From: Nicholas Lack <>
Sent: 23 October 2019 09:59
To: Maria Tomalova <>
Subject: Planning Application BN/66/19/PL, Canal Mews, Barnham.

APPLICATION NO: BN/66/19/PL

Site Address: Land off Canal Mews Barnham PO22 0AB

Description of Works: Erection of 3 No dwellings.

Drainage Strategy Drawing

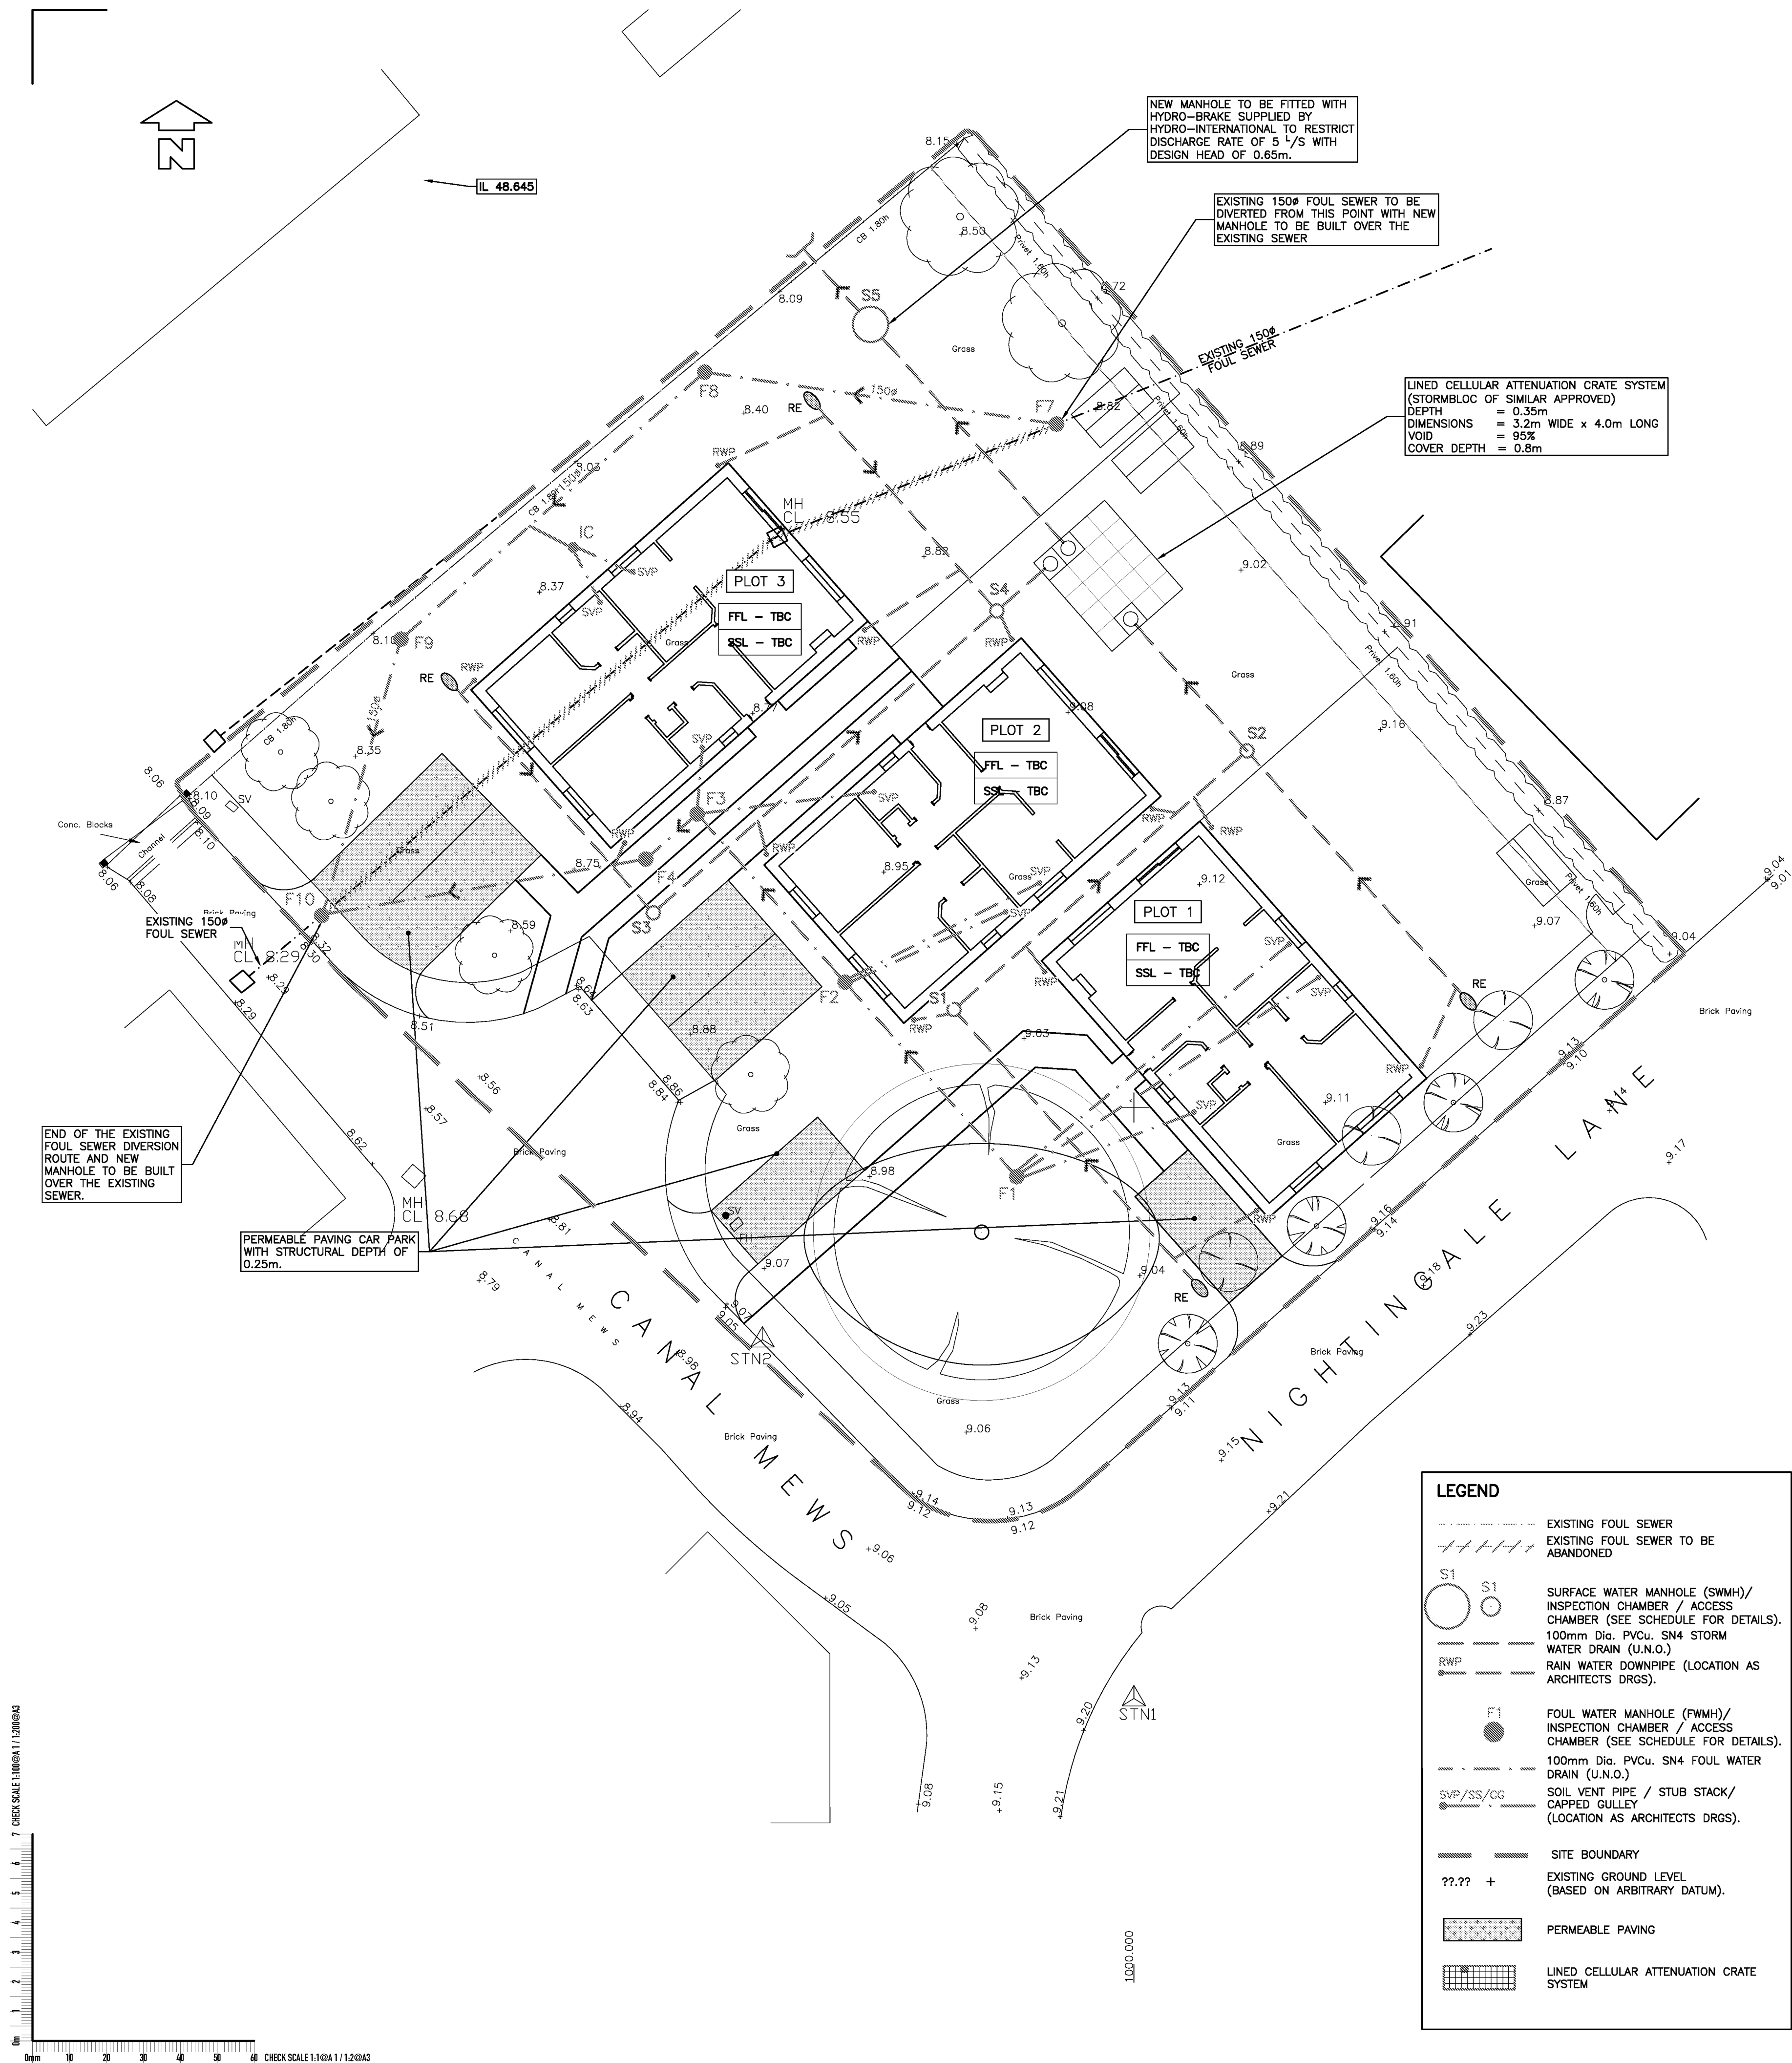
Full details of the foul water drainage system constructed as an alternative to the sewage treatment plant that was originally proposed.

It appears that the documents submitted in support of a discharge of conditions application (reference BN/25/14/DOC) for the wider site indicate that a foul water treatment plant is located in the area of the proposed development. Please can the applicant confirm if this is the case or not. Until such time as this confirmation is provided we object to the application.

What we think has happened in relation to Laura Gibbons comments, and one of the residents is that originally our application site was earmarked for a sewerage treatment plant but this was never constructed as it was found to be feasible to connect all the houses to the existing foul water sewerage system directly. Perhaps they are citing out of date drainage plans?
